Our ref: 24/10021/PREP
Enquiries to: Mr Matthew Adamson
E-mail: Matthew.Adamson@eastriding.gov.uk
Date: 12 March 2024

Proposal:	Proposed erection of a dwelling
Location:	Land South West Of The Uplands 96, Beverley Road, South Cave, East Riding Of Yorkshire, HU15 2BB,
Applicant:	Kennedy Steel
Application Type:	Pre Application Planning Enquiry

SITE PLAN AND  
LANDSCAPE PLAN

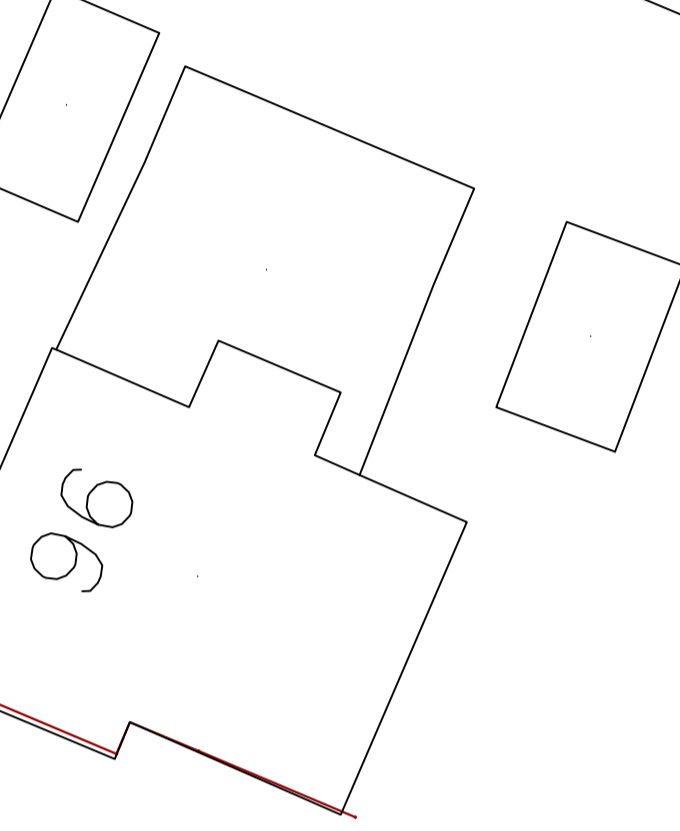
The only concern that I would raise in relation to the design of the proposal is the location of the detached garage to the front of the proposed new dwelling, in close proximity to Beverley Road. Although the existing trees and planting along the front (western) boundary of the site would partly screen the garage (if retained), there are no other detached garages to the front of properties along this part of Beverley Road which are highly visible from the public highway of Beverley Road and it would lie in front of the existing line of development. Consideration should be made into either repositioning the garage so it would be less visually prominent from Beverley Road, or that it is incorporated and attached to the proposed new dwelling.

The Council's Sustainable Transport Supplementary Planning Document states that a four-bedroom property located in a 'Primary Village' such as South Cave would require two to three on-site parking spaces. As the vehicular access to the site from Beverley Road would be located at the 40mph section of Beverley Road, it is imperative that vehicles can both enter and exit the site in forward gear. I have informally discussed the application with a member of the Council's Highways team. The Highway Officer indicated that the site lines along this section of Beverley Road are clear and would be suitable for a new vehicular access to be created. However, the Officer did raise concerns regarding the location of the garage and recommended that if it is intended to construct the garage in the location proposed in the development statement, then a swept path analysis should be included as part of the application to demonstrate parking in the garage would be possible when two other motor vehicles are already parked on the driveway. This is required as the Highway Officer believes that it would be difficult to have two parked motor cars on site and for a motor vehicle to still be able to access the garage.

The provided development statement makes no reference to how drainage would be provided for proposed new dwelling. Should mains sewer be proposed as the means of disposing foul water from the development, then the capacity, routing and connections, etc. of the foul system would be subject to consultation with Yorkshire Water at the time of any application for planning permission. Any alternate means of drainage would be subject of consultation with the Council's Land Drainage team.

Front Elevation

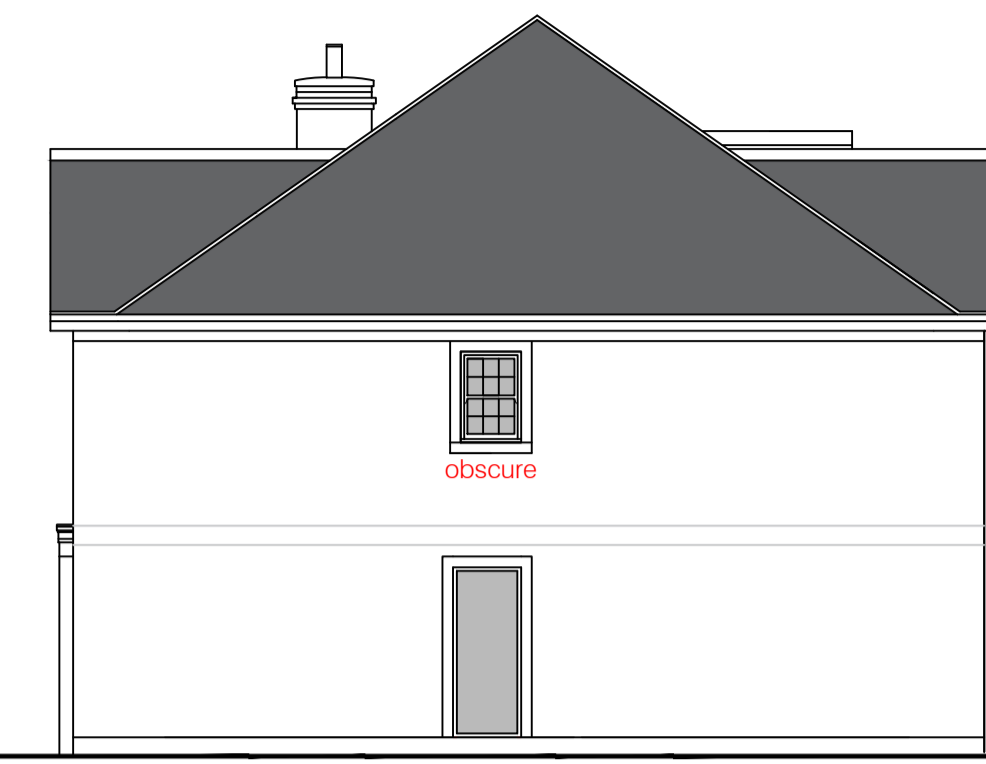
The design of the proposal would be contemporary in appearance and the new dwelling would be set back from Beverley Road. This would complement the appearance of the properties to the south of the application site; Beverley Road consists of a mixture of properties which vary in style between traditional and modern and there have been several 'back-land' developments along this part of Beverley Road. The development statement sets out that the materials used in the construction of the proposal would correspond to the style of the surrounding dwellings and their facing brickwork and slate roof tiles.

It is proposed to install to ground floor windows and a first floor window along the northern elevation of the new dwelling. The ground floor windows would be secondary windows serving the lounge of the new dwelling and the first floor window would serve an en-suite bathroom. As these windows are either secondary windows or serve a non-habitable room, it is recommended that these windows are either obscure glazed or set above 1.7m from the finished floor level of the room they serve. This is to ensure that these windows would not create any opportunities to overlook the private rear garden of the neighbouring property at no.96. It is noted that the ground floor windows may be acceptable if adequate screening is in place along the shared boundary to prevent any overlooking from these windows.

There would be a door and a first floor window installed along the southern elevation of the proposed new dwelling with the first floor window serving a dressing room. This window would have to be obscure glazed and non-opening below 1.7m of the finished floor level as it would face directly onto no.82 which also has a first floor clear glazed window installed along its northern elevation. As this window would serve a dressing room, a non-habitable room, it is considered that an obscure glazed window would be acceptable for this room.
